## **SECTION 4.55(1A) MODIFICATION APPLICATION TO SSD7228 SYDNEY ZOO – MODIFICATION 2**

This application has been prepared by Ethos Urban on behalf of Sydney Zoo, pursuant to section 4.55(1A) of the *Environmental Planning and Assessment Act 1979* (EP&A Act) to modify State Significant Development Consent 7228 relating to Bungarribee Park (Western Sydney Parklands) the Sydney Zoo in Bungarribee Park, Western Sydney Parklands (the site).

The modification relates to the reconfiguration of the aquatic habitat exhibit and its associated boardwalk access path.

BUILDING 6_AQUATIC HABITAT

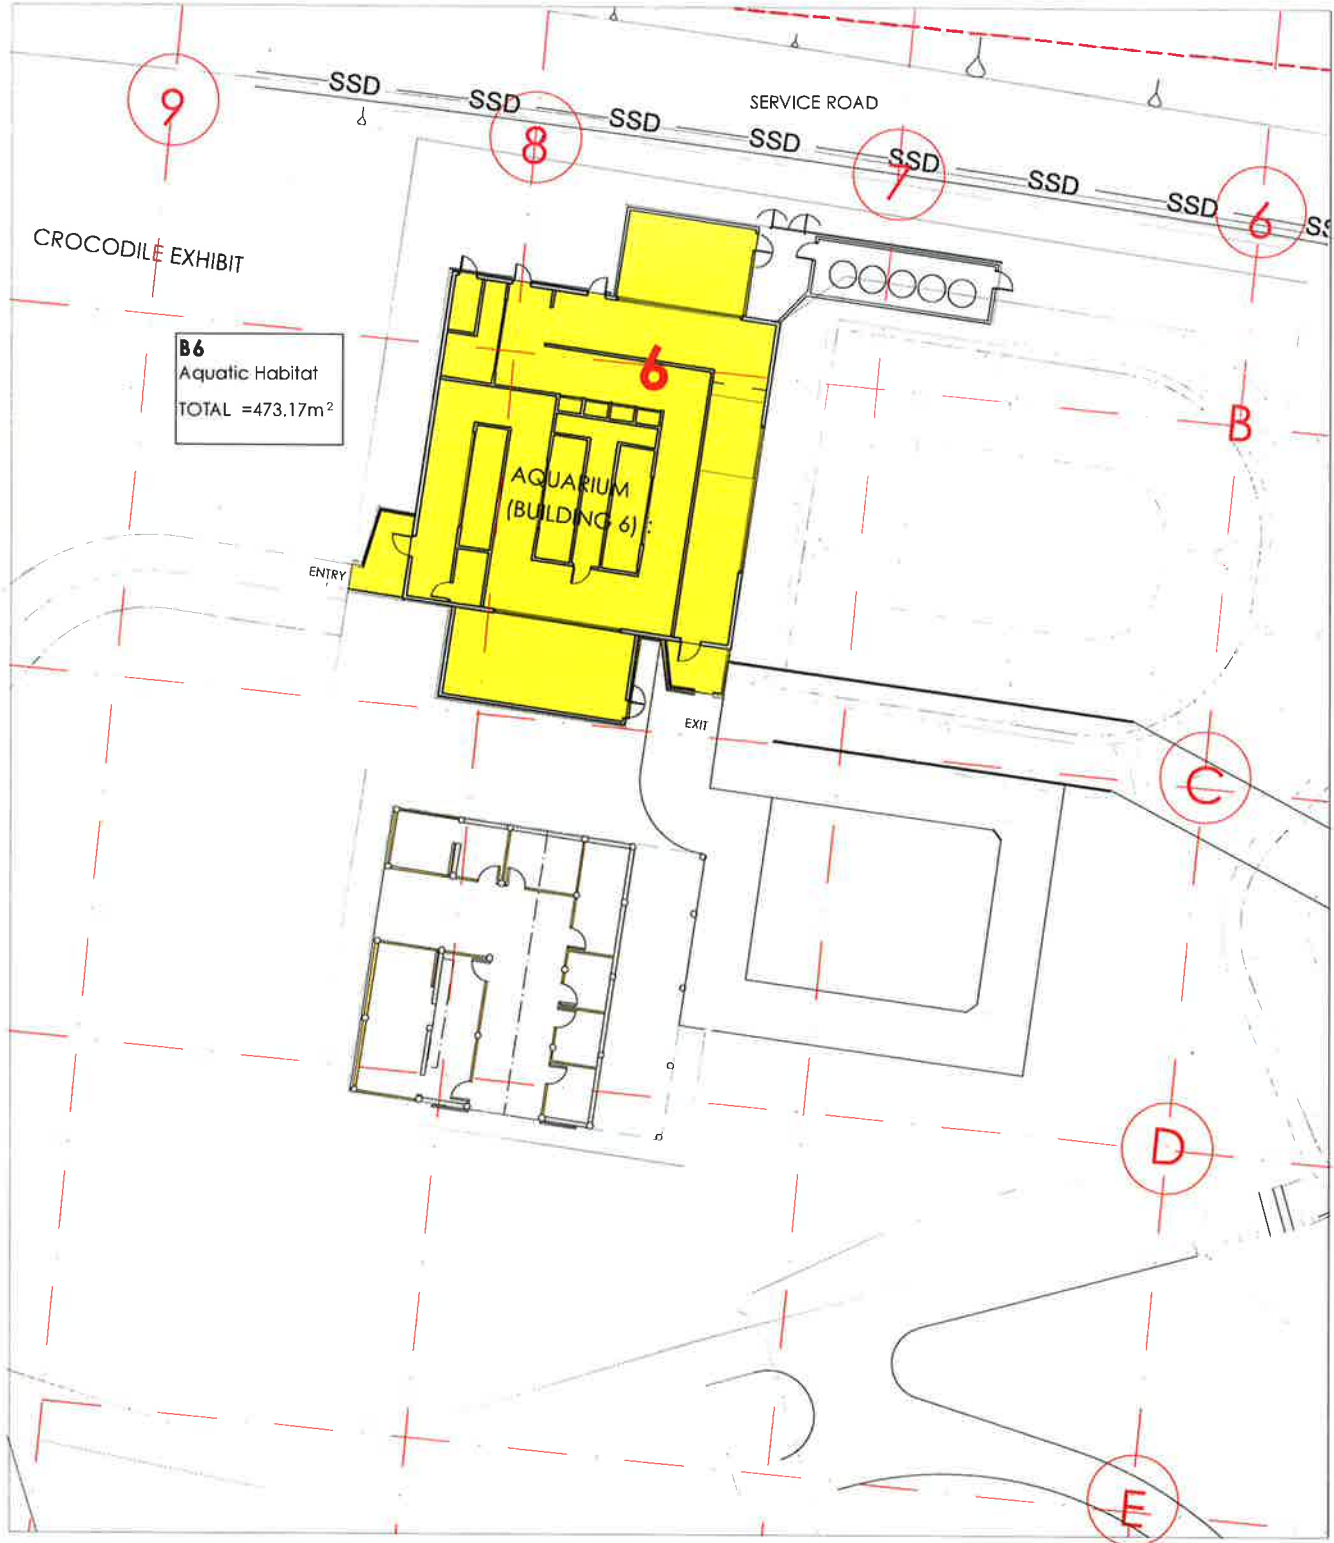
- Reconfiguration of the aquatic habitat including:
  - Reorientation of the built form to a north-south direction and internal layout reconfiguration within the building;

- Realignment of the boardwalk access path to the Aquatic Habitat.
- Amendment to the Landscape Plan to ensure it reflects the already assessed and approved back-of-house building arrangements for the African Grasslands. The approved detailed architectural plan provides for a sheltered component to the stalls, which the Landscape Plan inadvertently did not reflect. The Landscape Plan is therefore also proposed to be updated as part of this Modification Application to amend this oversight.

The boardwalk access path is now proposed to deck over the stormwater basin, and is proposed to be similar in style to boardwalk proposed at the western end of the zoo.

Floor Plan
Aquatic Habitat Exhibit
B6

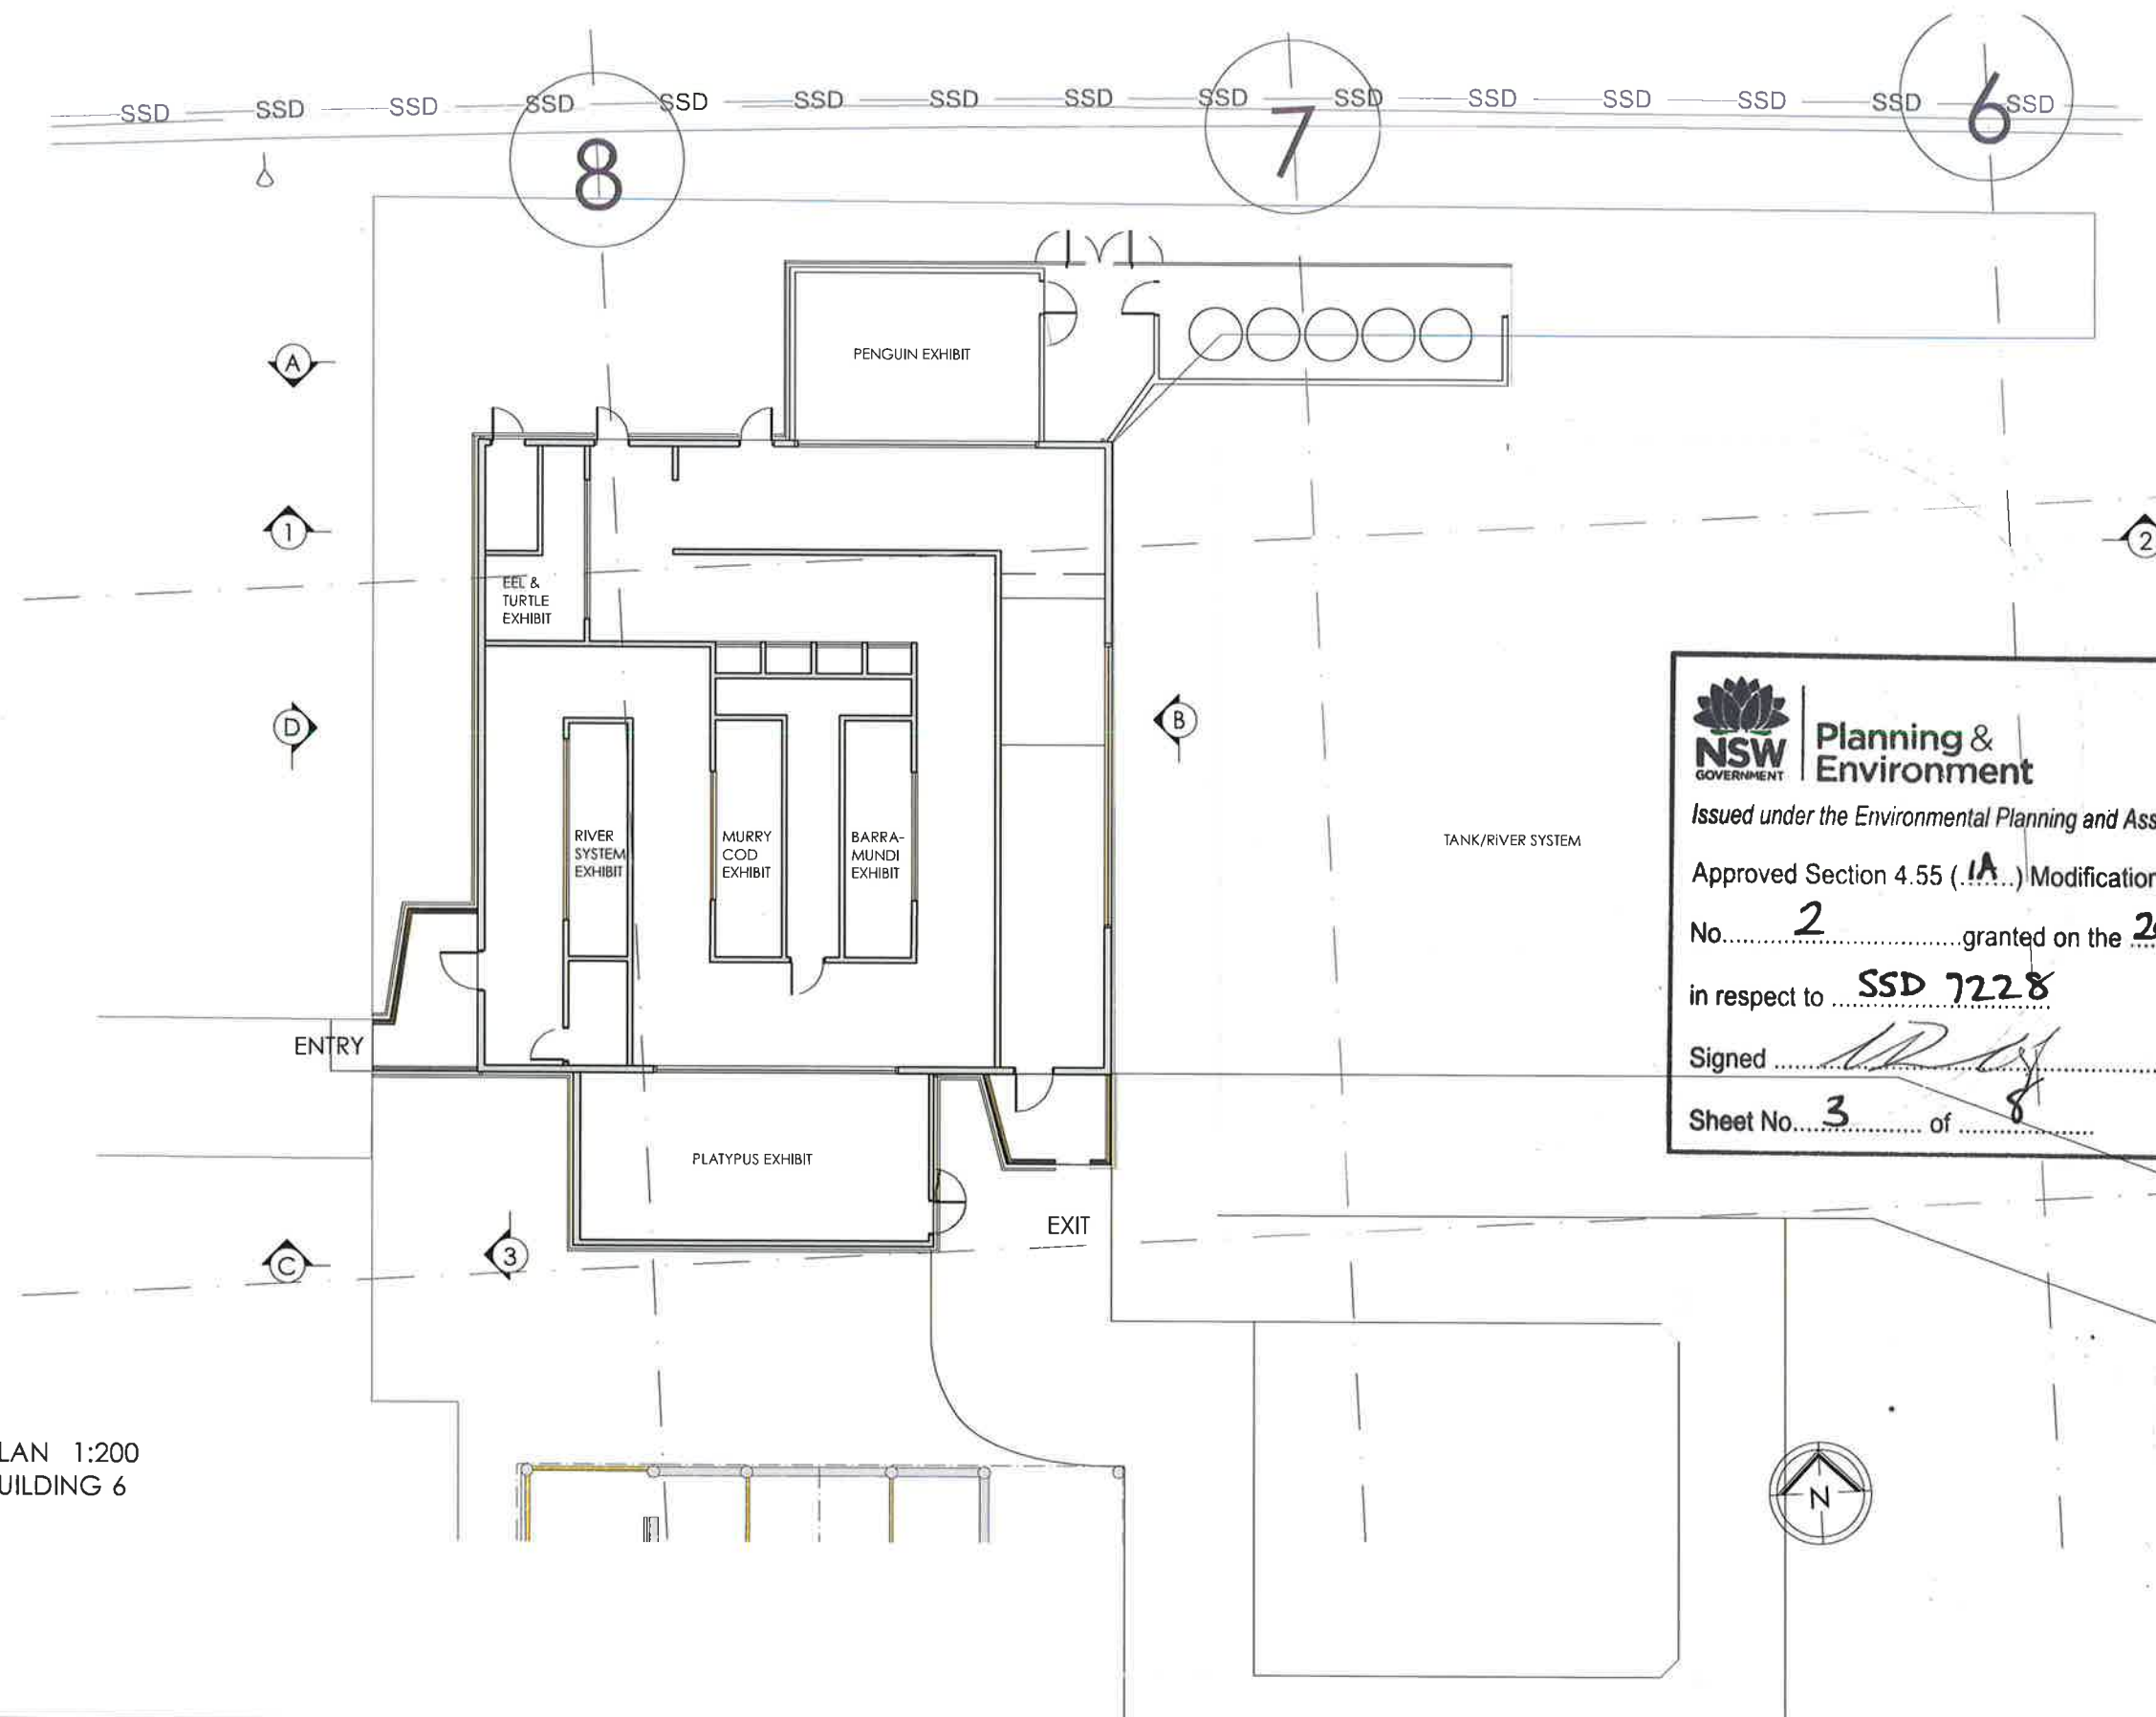
- Change in the design to a more traditional above-ground building;
  - Increase in floor space to 473m<sup>2</sup>, up from 343m<sup>2</sup>;
  - Inclusion of a tank to create an outdoor component to the aquatic habitat;

ELEVATION A _ NORTH 1:100
BUILDING 6

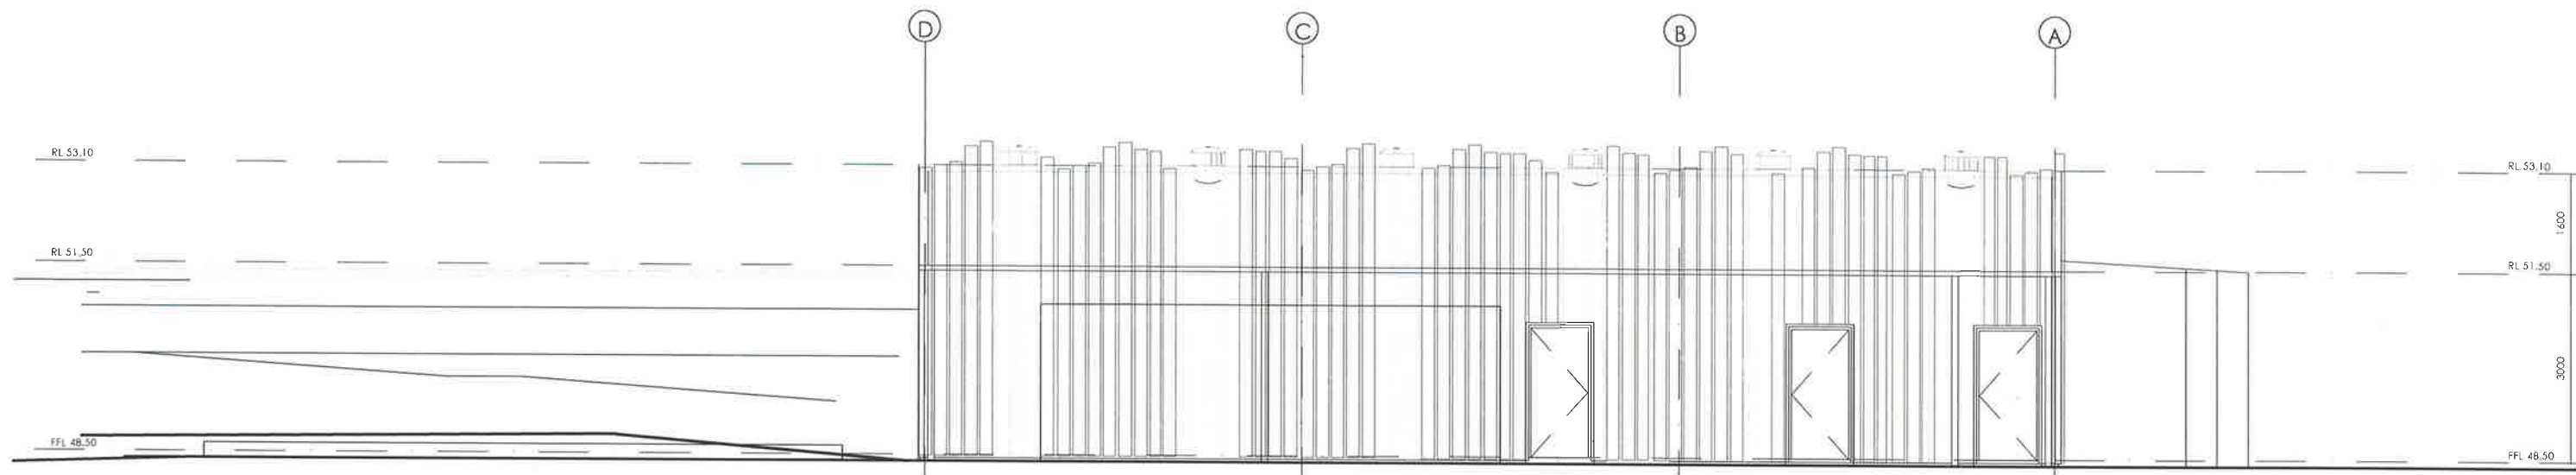
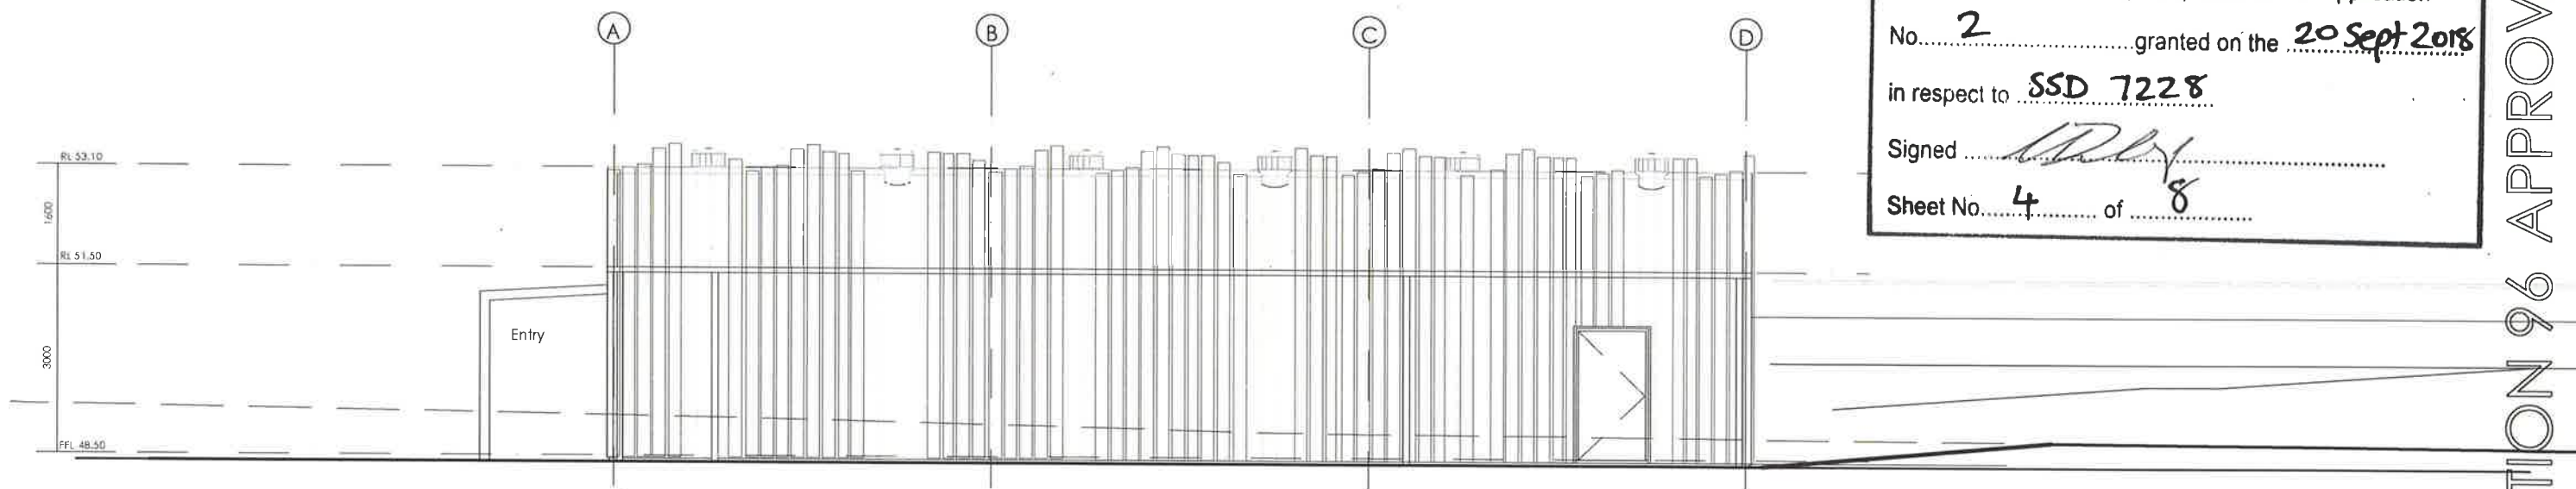
Whilst the general bulk, scale and arrangement of the proposed building is largely consistent with the approval, the architectural style has been altered in a way that would change the appearance of the building. The building was originally approved as a bunker style building with vegetation planting placed over the roof, similar to the nocturnal and reptile habitat building. As part of this Modification Application, the proposed aquatic habitat building will be of a more traditional construction comprising a structural steel frame and cross laminated timber panels to be clad with recycled timber, similar in architectural style to the style of the main entry and restaurant buildings.
